# CITY OF ALBUQUERQUE

**Re: Purvis Industries  
Erosion Sediment Control Plan  
Engineer's Stamp Date 9-21-15 (F17E097)**

SITE PLAN

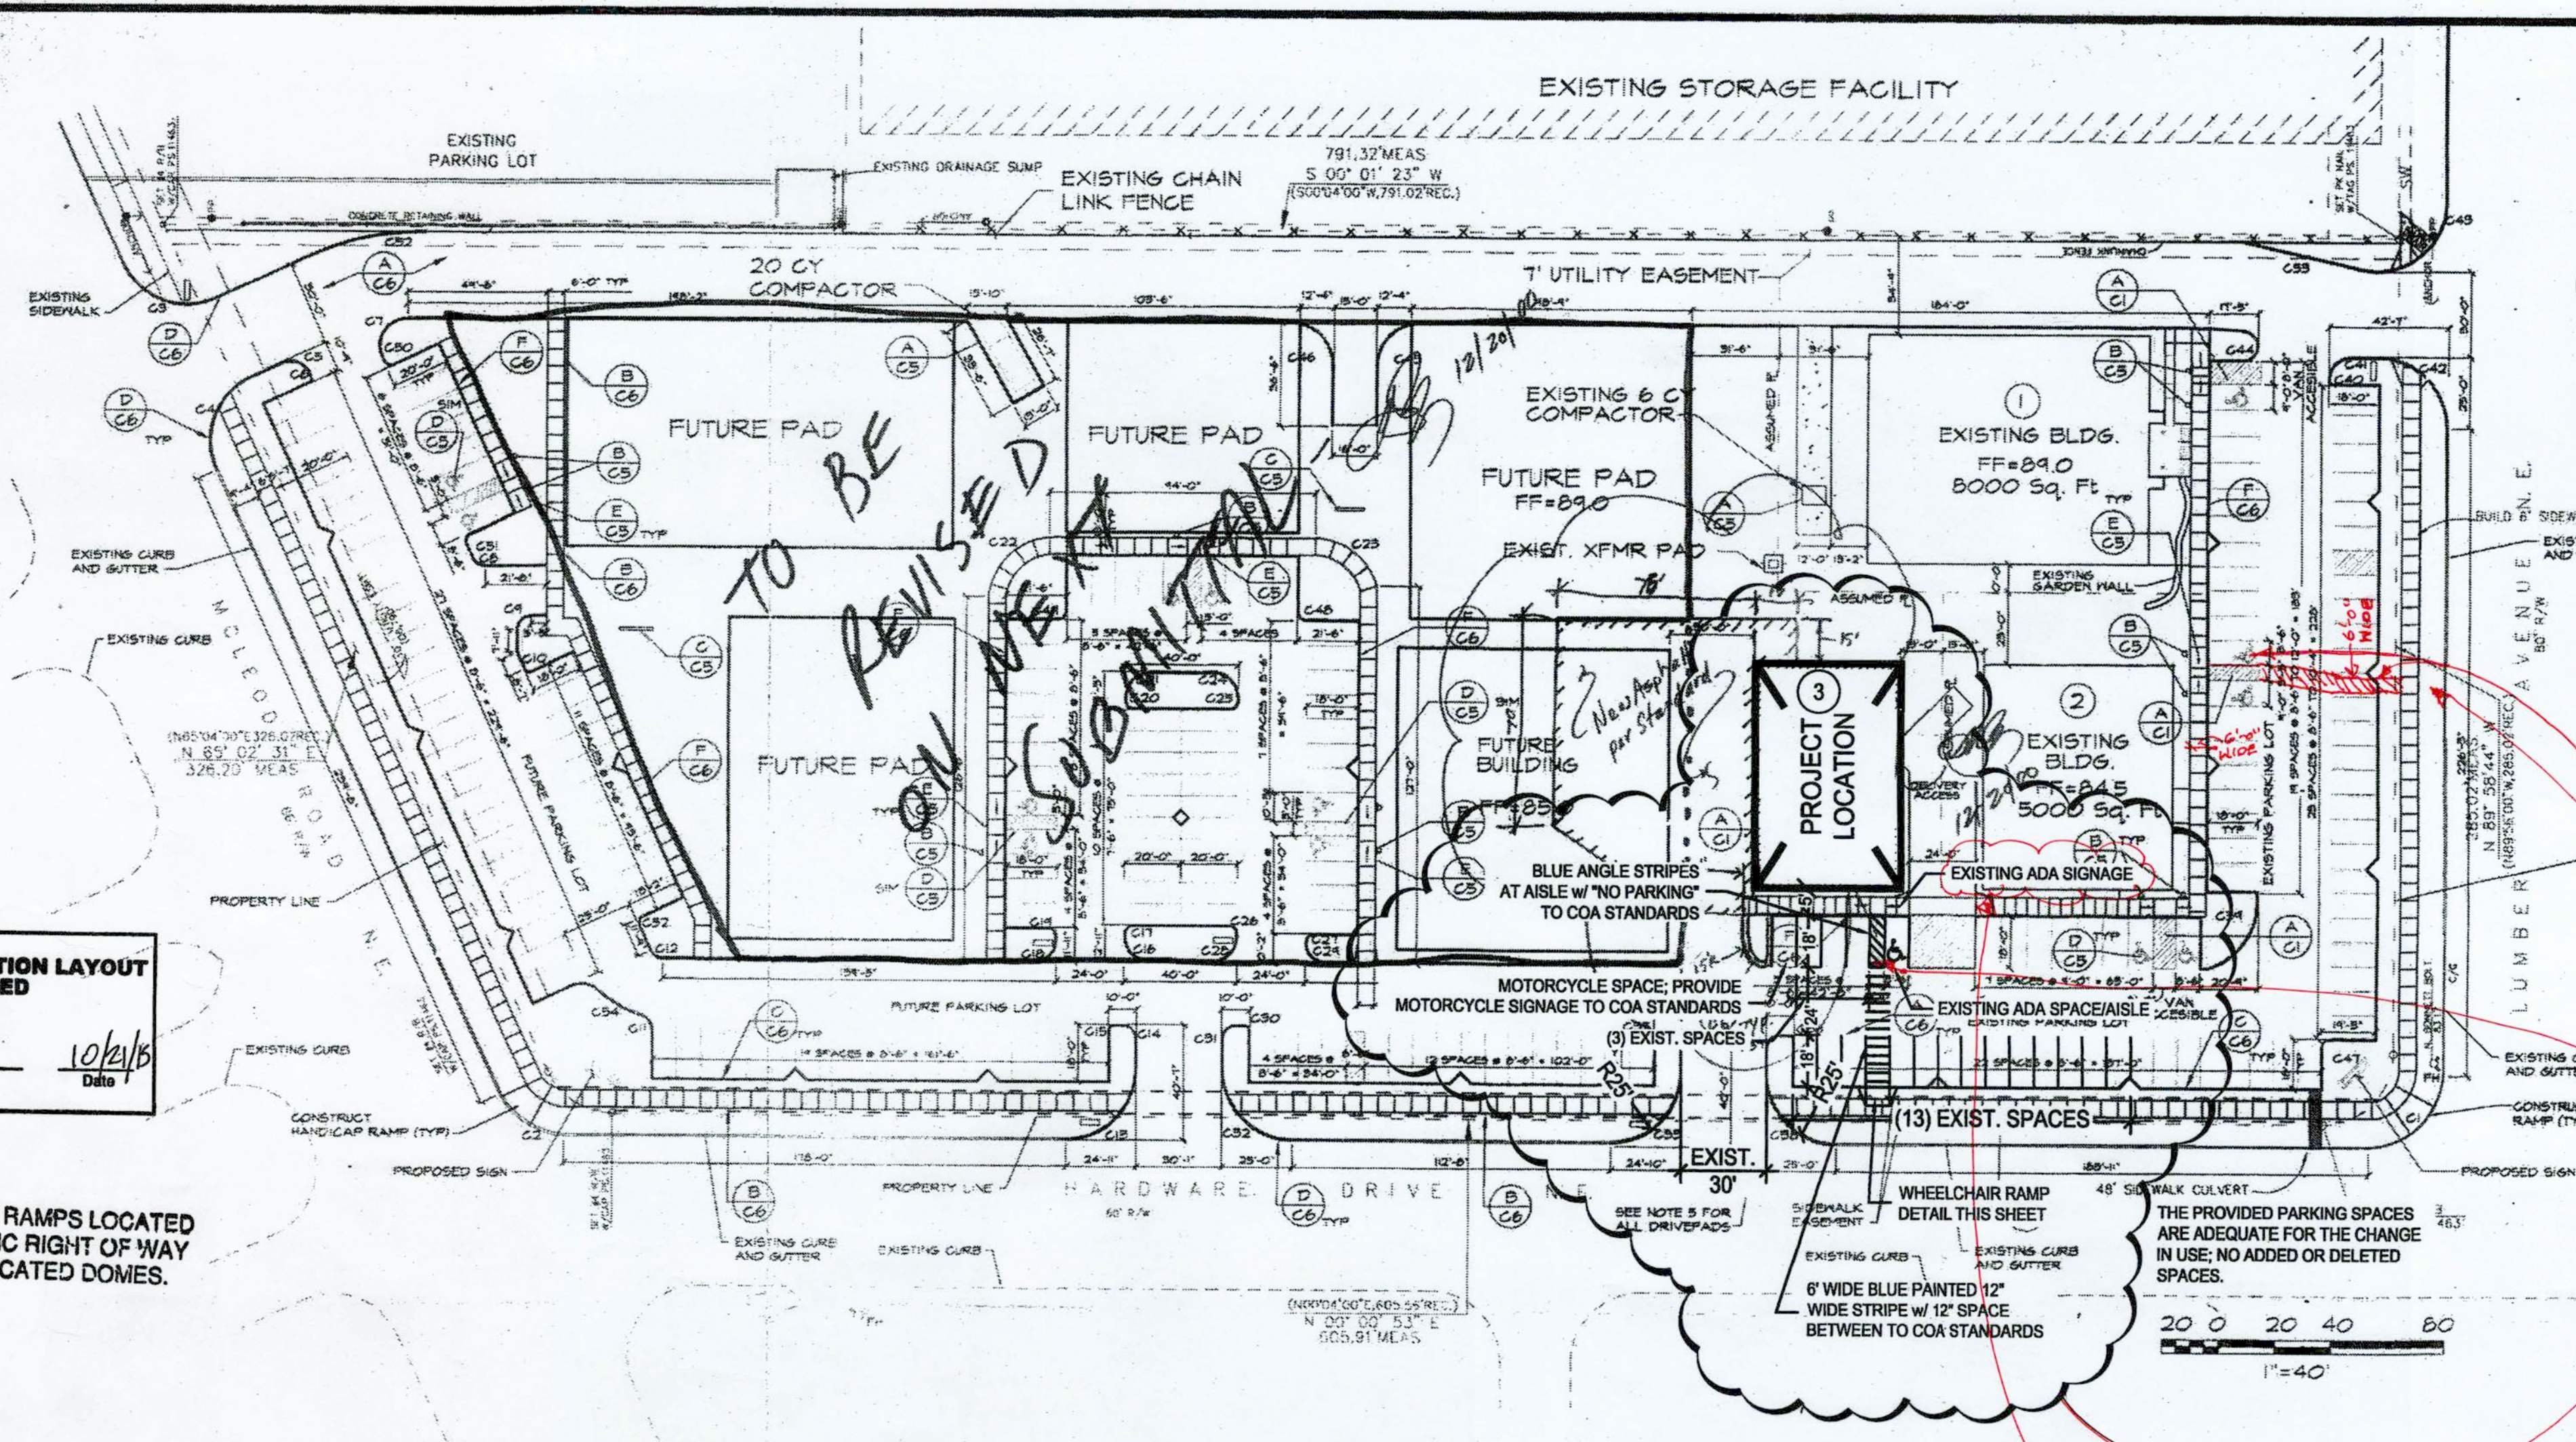
If possible, the construction entrance should be moved from Midway Park Blvd to Singer Blvd since it is on the higher side of the site.
